This is to certify that Brown Robyn O &/Butler, Michael  
 has permission to Remove and Replace 16' x 16' shed to be used as storage. Exchange replacement  
 AT 32 Lincoln St City of Portland 125 K002001

# All Purpose Building Permit Application

CHECK-LIST AGAINST ZONING ORDINANCE

Proposed Use/Work - Replace existing 17'x20' Garage w/ 16'x18'

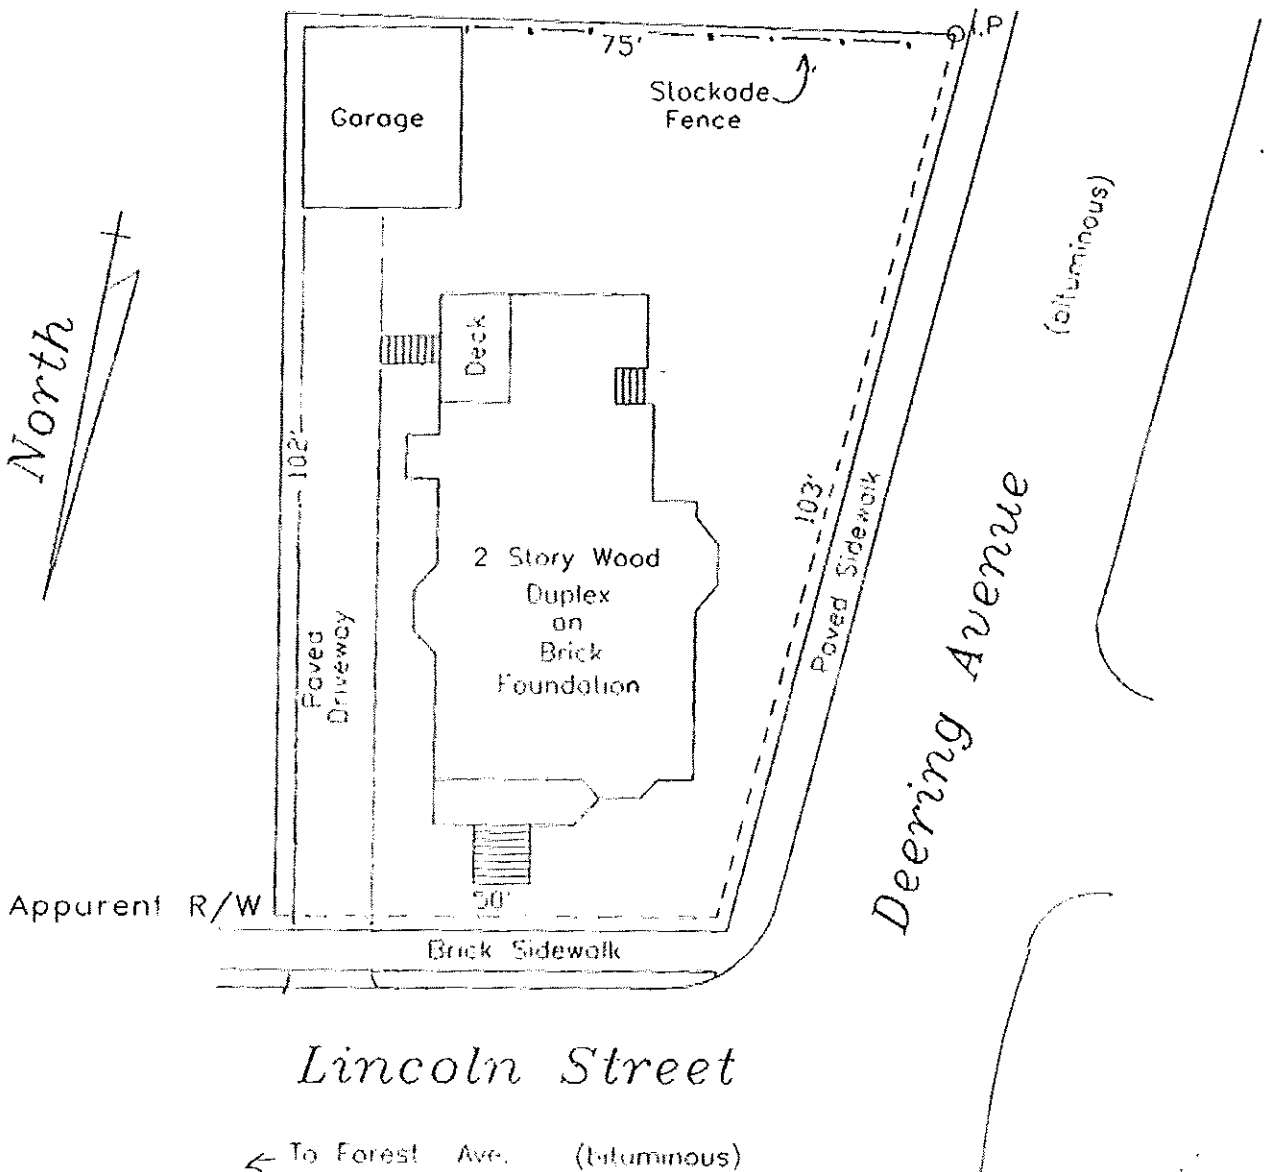
Rear Yard - 20' Req 1' shown > per sec. 14-382

Side Yard - 8' Req 2' shown →

OK - replacement of non-conforming existing building

Actually Reducing size and decreasing non-conformity

This structure is legally non-conforming as to setbacks. Per Sec. 14-382 it may be re-built in the exact same footprint, size and height within a year of demollition. Per the plans, you show that the structure will actually decrease in size and be situated within the same footprint.
